**KIRKLEES METROPOLITAN COUNCIL
INVESTMENT & REGENERATION SERVICE**

Reference No: 2021/62/91208/E

Site Address: Former Pizza Hut Restaurant, Centre 27 Business Park, Bankwood Way, Birstall, Batley, WF17 9TB

Description: Installation of drive-thru lane and associated engineering works, alterations to car parking and servicing arrangements and associated changes to landscaping. Demolition of existing enclosed yard and provision of replacement bin store, minor alterations to the building and elevations including recladding

Title:
PROPOSED BIN STORE

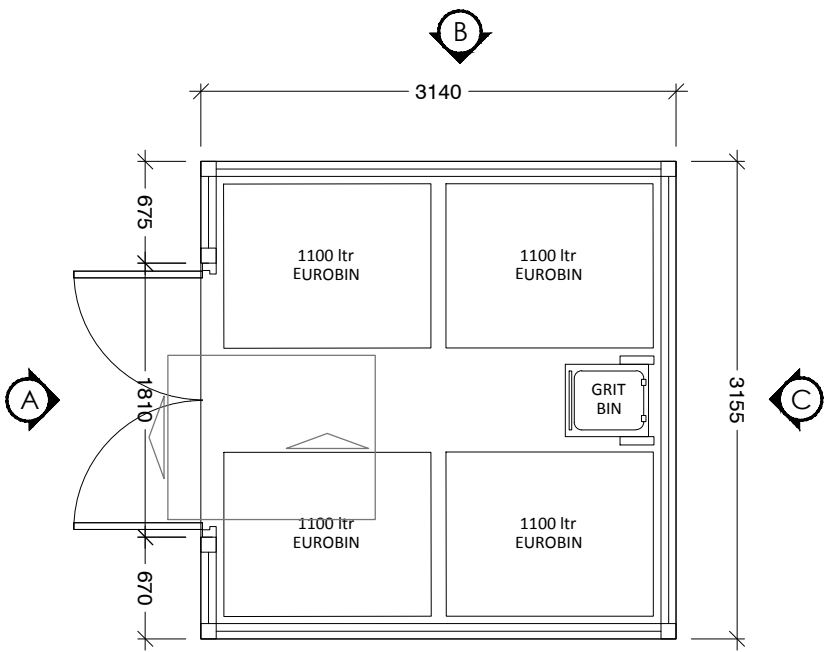
A drive-thru lane is proposed to the west of the entrance to the site, which would run to the northern elevation of the building. The lane would include two points of access, guided by two raised islands. To facilitate the provision of the drive-thru lane, alterations are proposed to the layout of the carpark. Minor alterations to the existing landscaping are proposed to facilitate the drive-thru lane and layout alterations. The existing enclosed yard and bin store to the north of the building would be demolished and a replacement bin store would be provided to the western elevation of the building.

Drawing No:
7330-PS-01.5

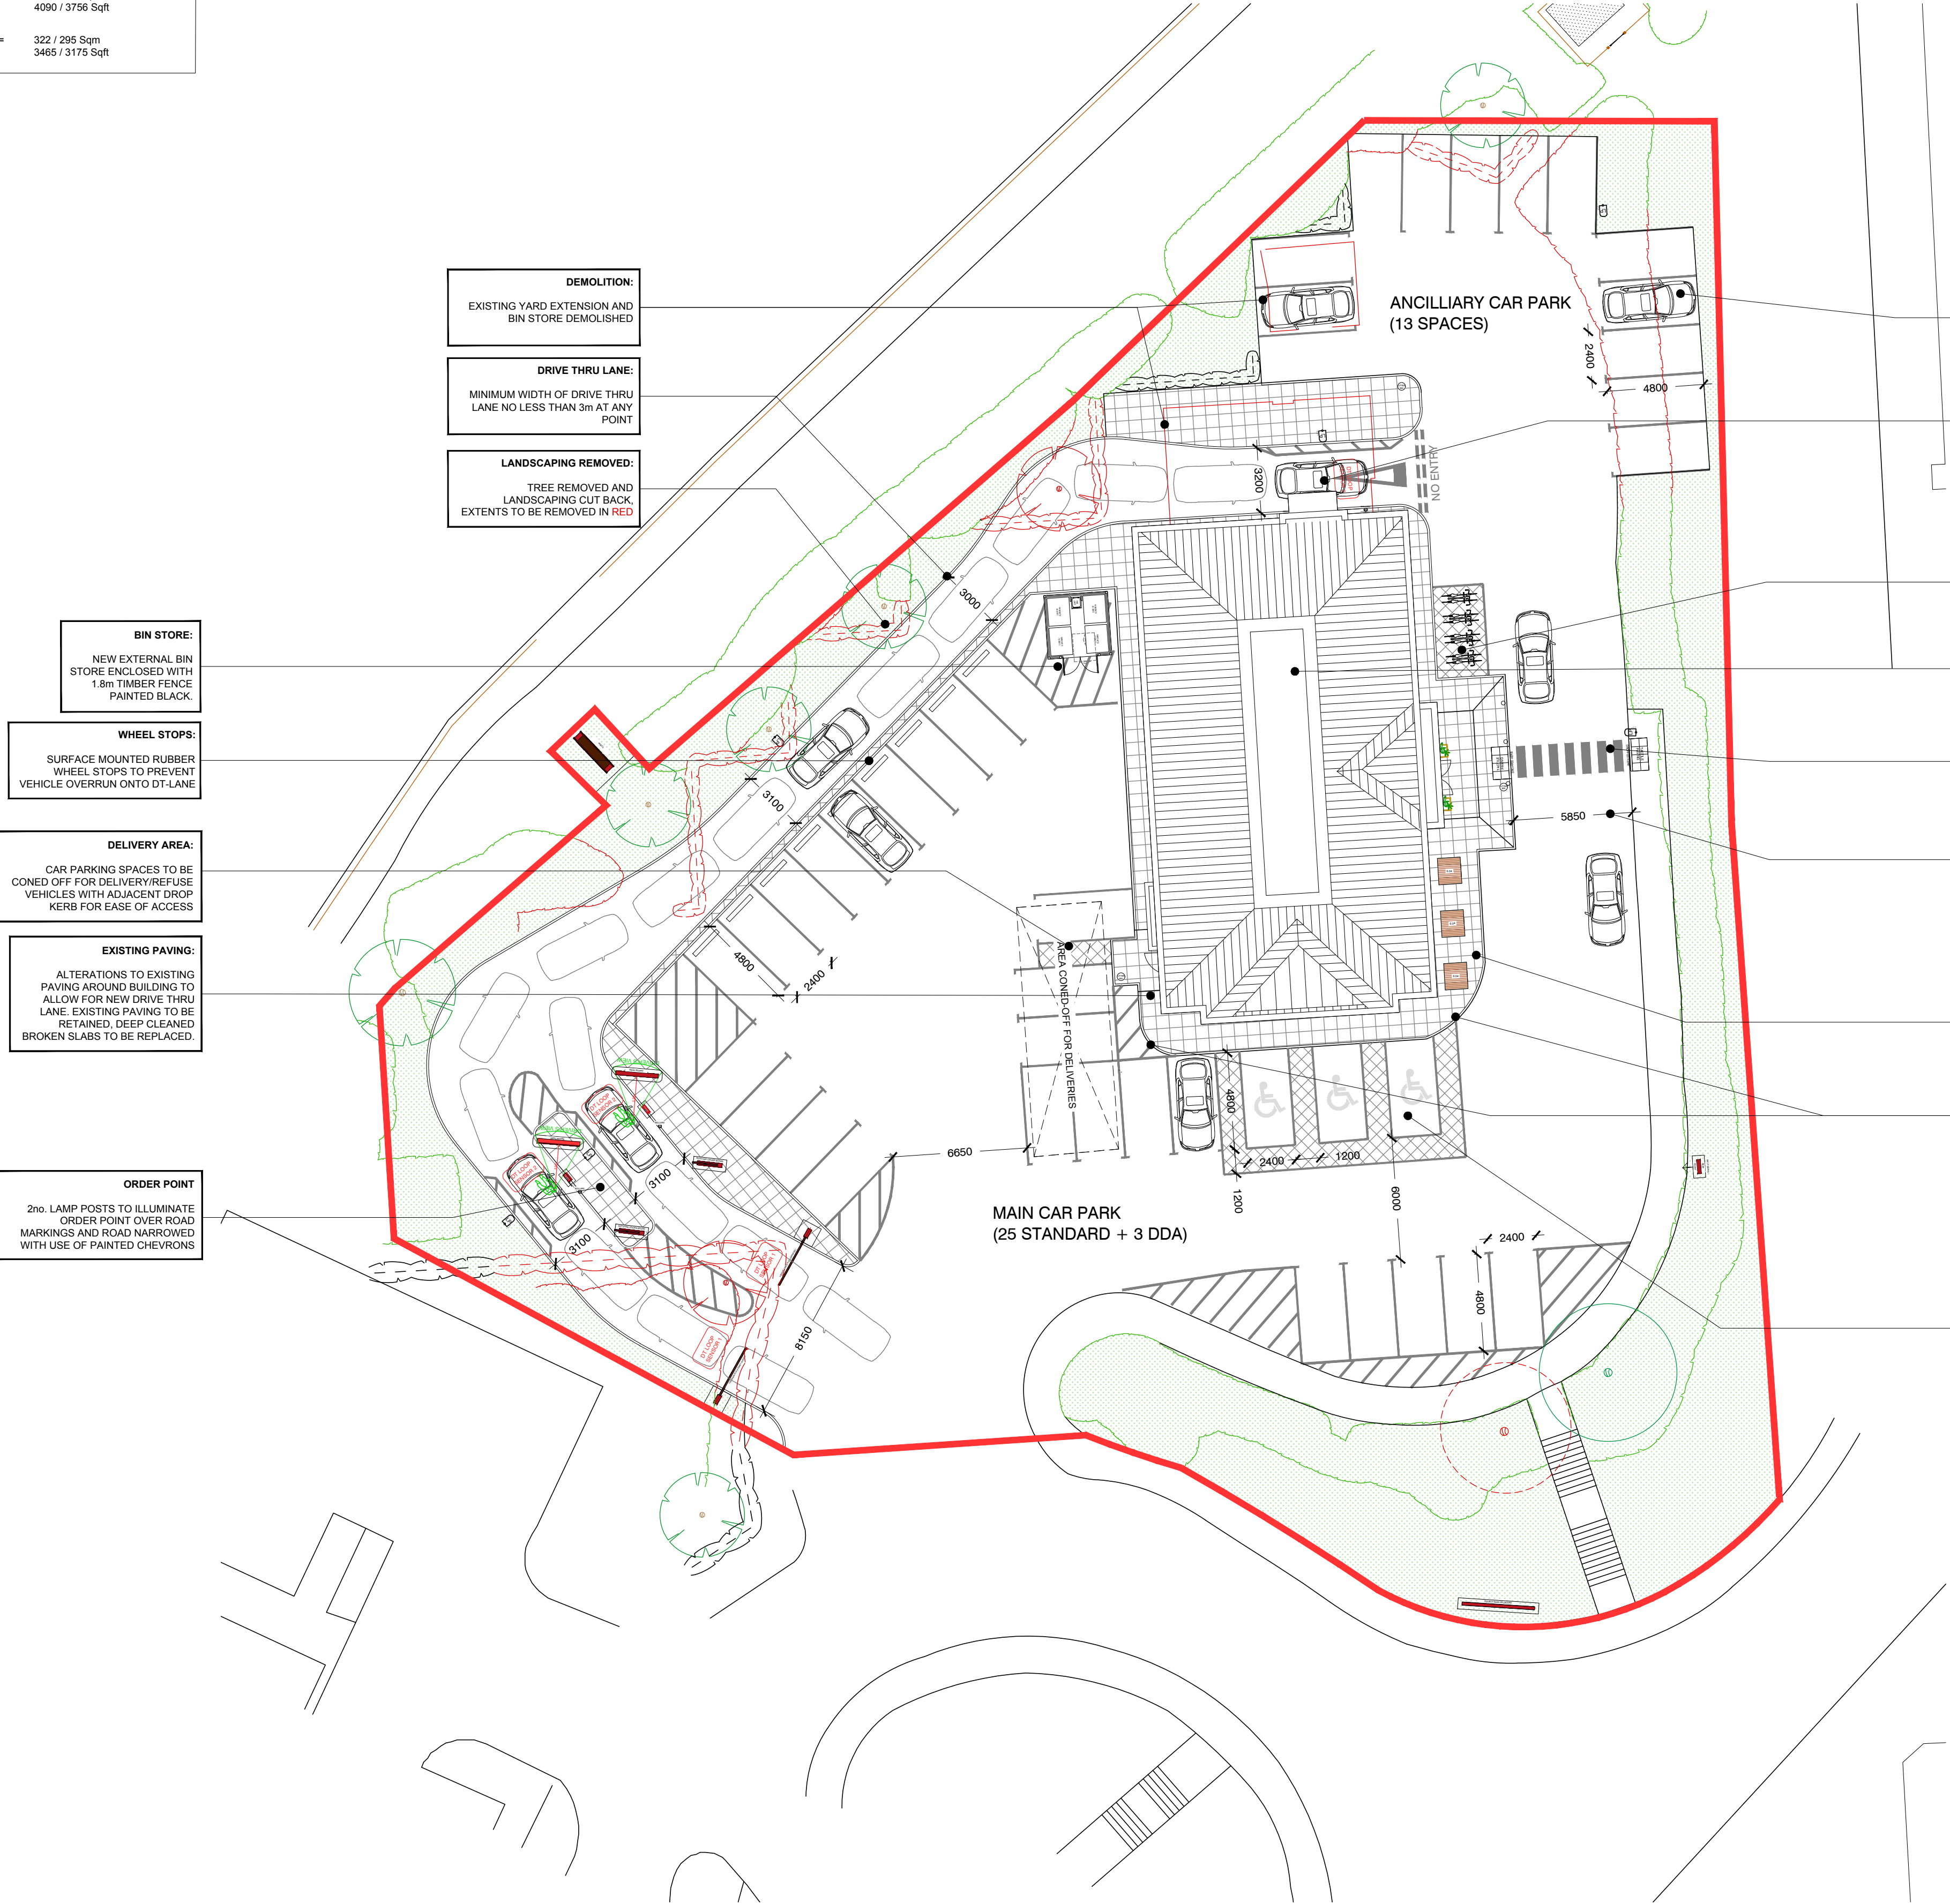
A revised site plan has been submitted during consideration of the application including additional details and information in response to a consultation response received by the Council's Highways Development Management team. Due to the nature of the amendments, the amended plan has not been advertised to the public in this case.

KC Highways Development Management (HDM) – Following the receipt of a revised proposed site plan, no objections have been raised.

Response – The proposed building would continue to operate as a restaurant and takeaway. It is however acknowledged that the introduction of a drive-thru lane could result in additional litter at the site. The proposed site plan shows that litter bins would be provided around the main building, which are considered sufficient for the purposes of this planning application.

3. Prior to the development being brought into use, the proposed carpark hereby approved shall be marked out into bays in accordance with details that have been previously approved in writing by the Local Planning Authority.
